Disability Access Report - SSD

HCDD Stage 1A
16B Honeysuckle Drive
NEWCASTLE NSW

For: University of Newcastle
c/- EJE Architecture
Ref: LP_18086

SITE: 16B HONEYSUCKLE DRIVE
NEWCASTLE, NSW, 2300
DRAWING: LEVEL 1 PLAN

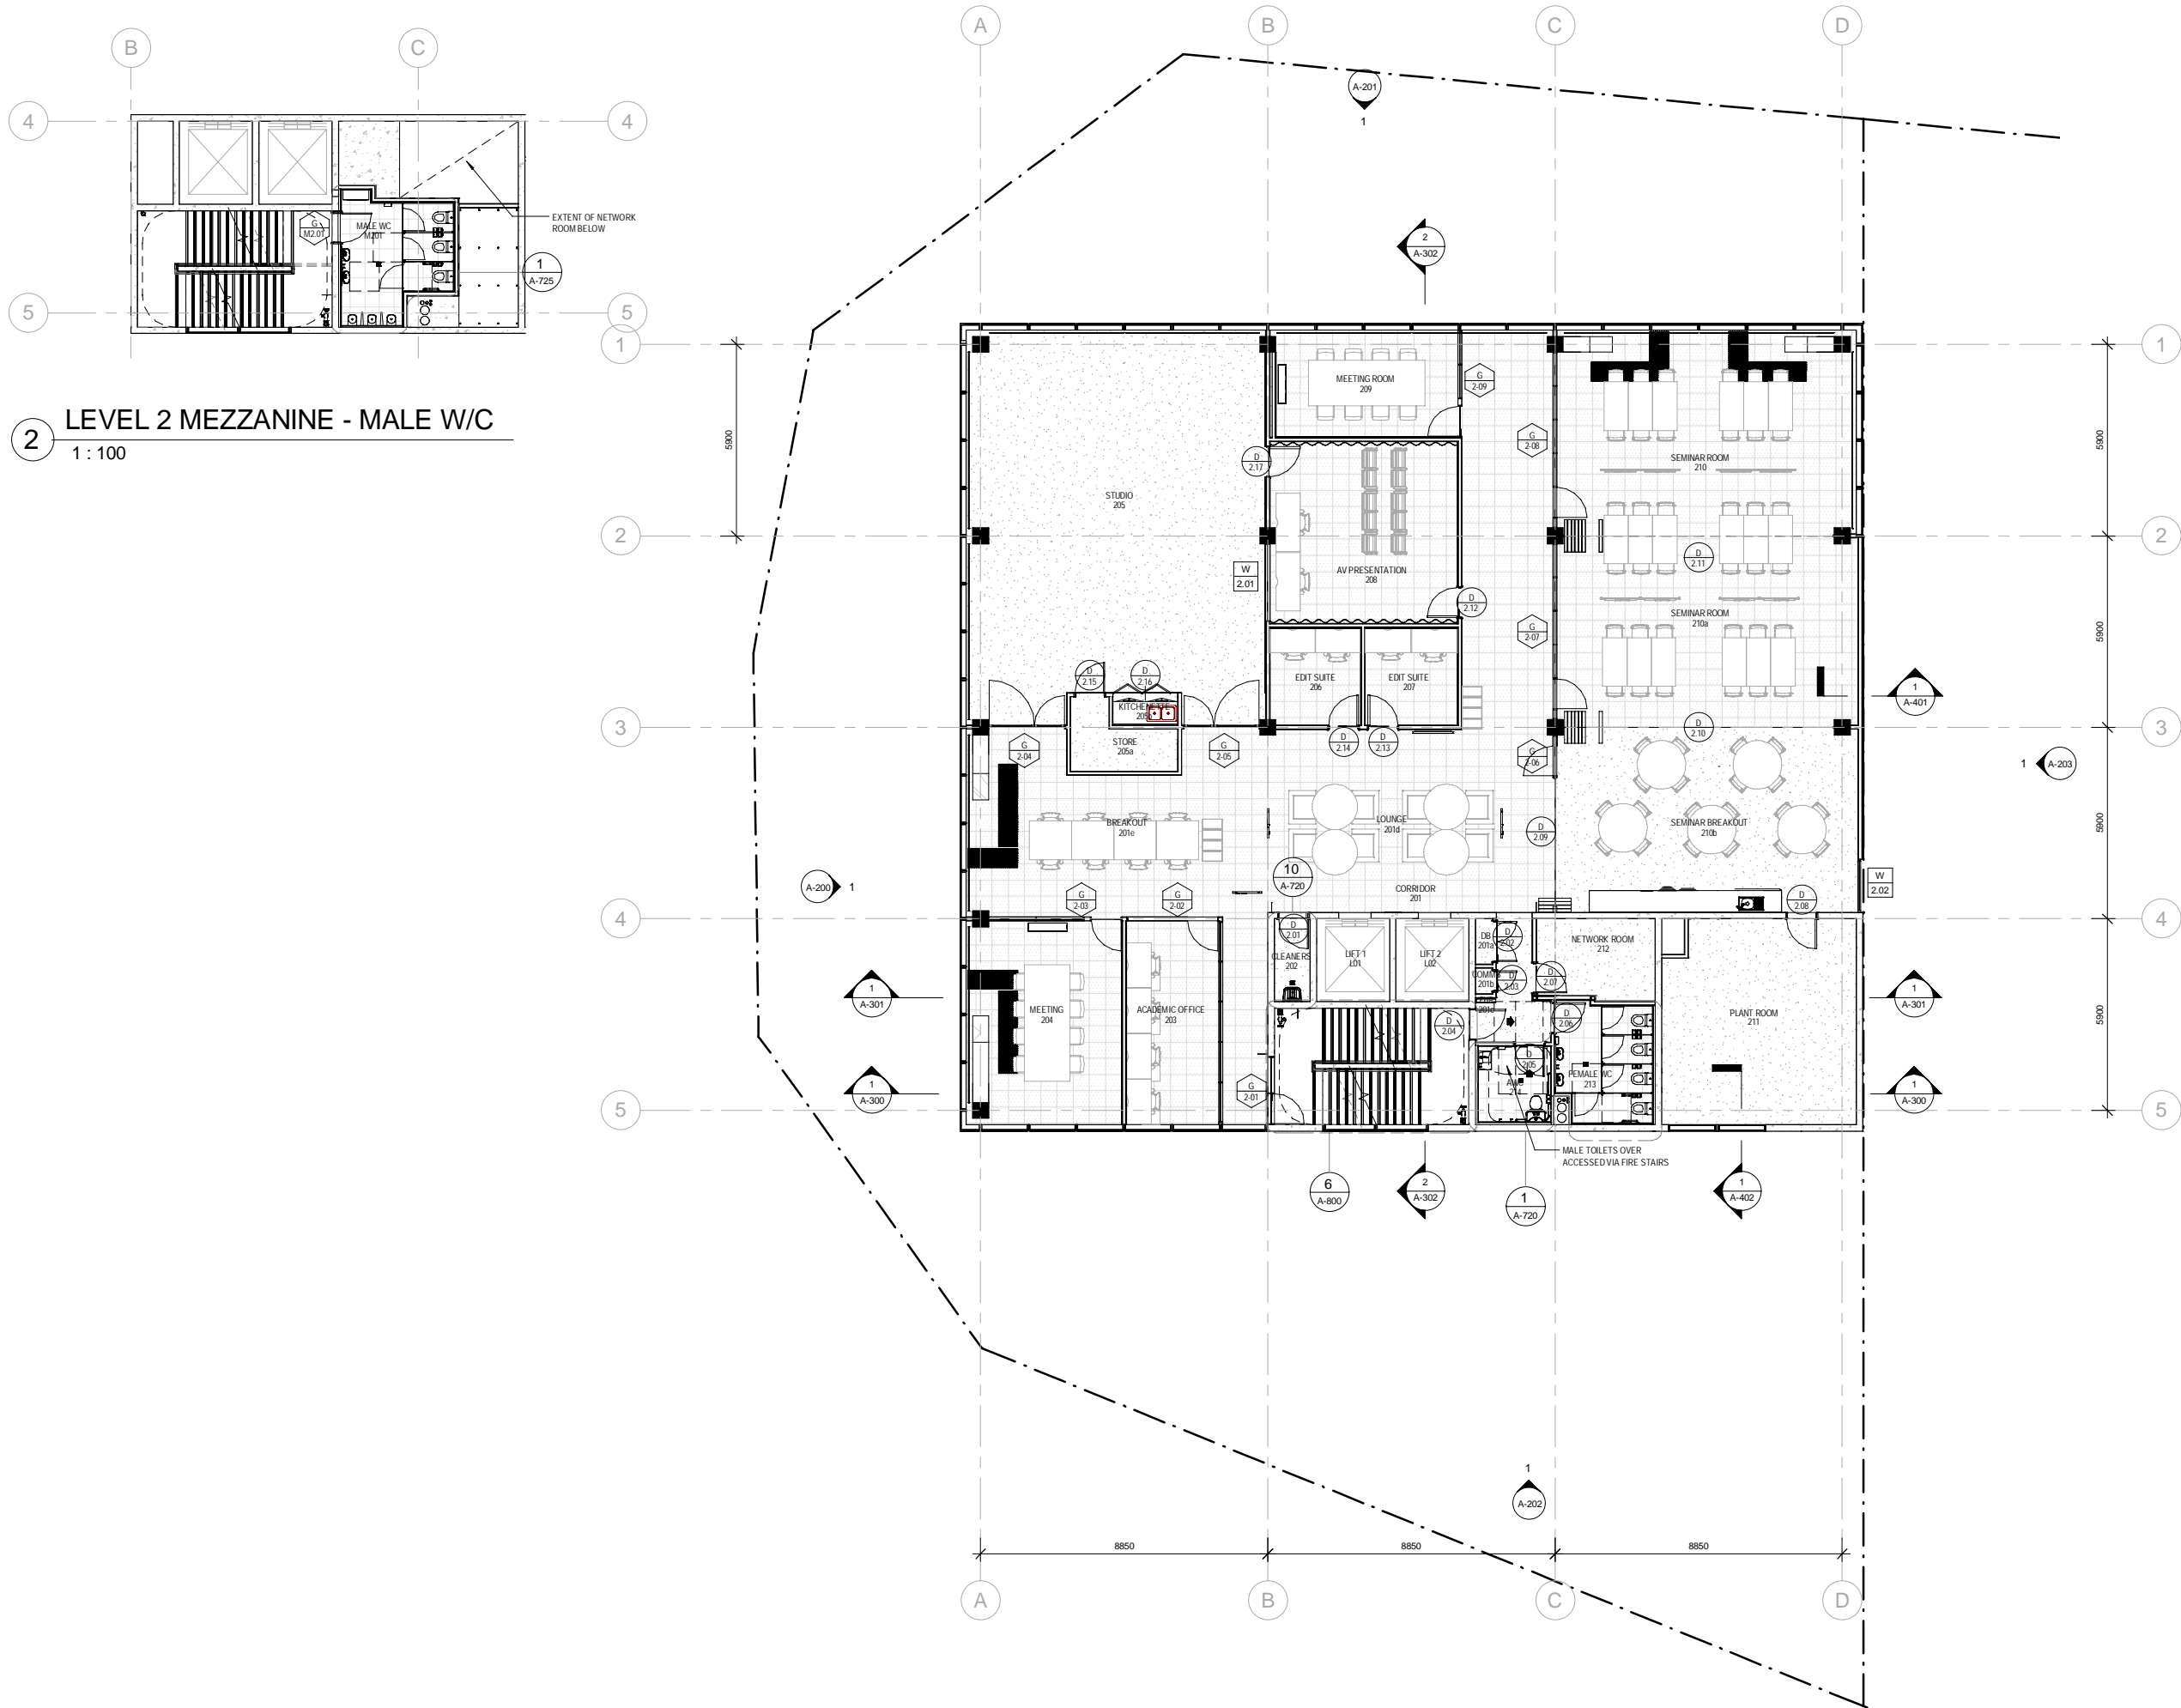
The provision of 1200 / 1400mm wide corridors at the Ground Floor Level / Level 1 respectively does not achieve the required wheelchair circulation areas.

- a. Provide turning spaces 1540mm wide by 2070mm long within 2m of the end of corridors to enable a wheelchair to turn through 90°.
- b. Provide passing areas 1800mm wide by 2000mm long every 20m along a corridor unless there is a clear line of sight.
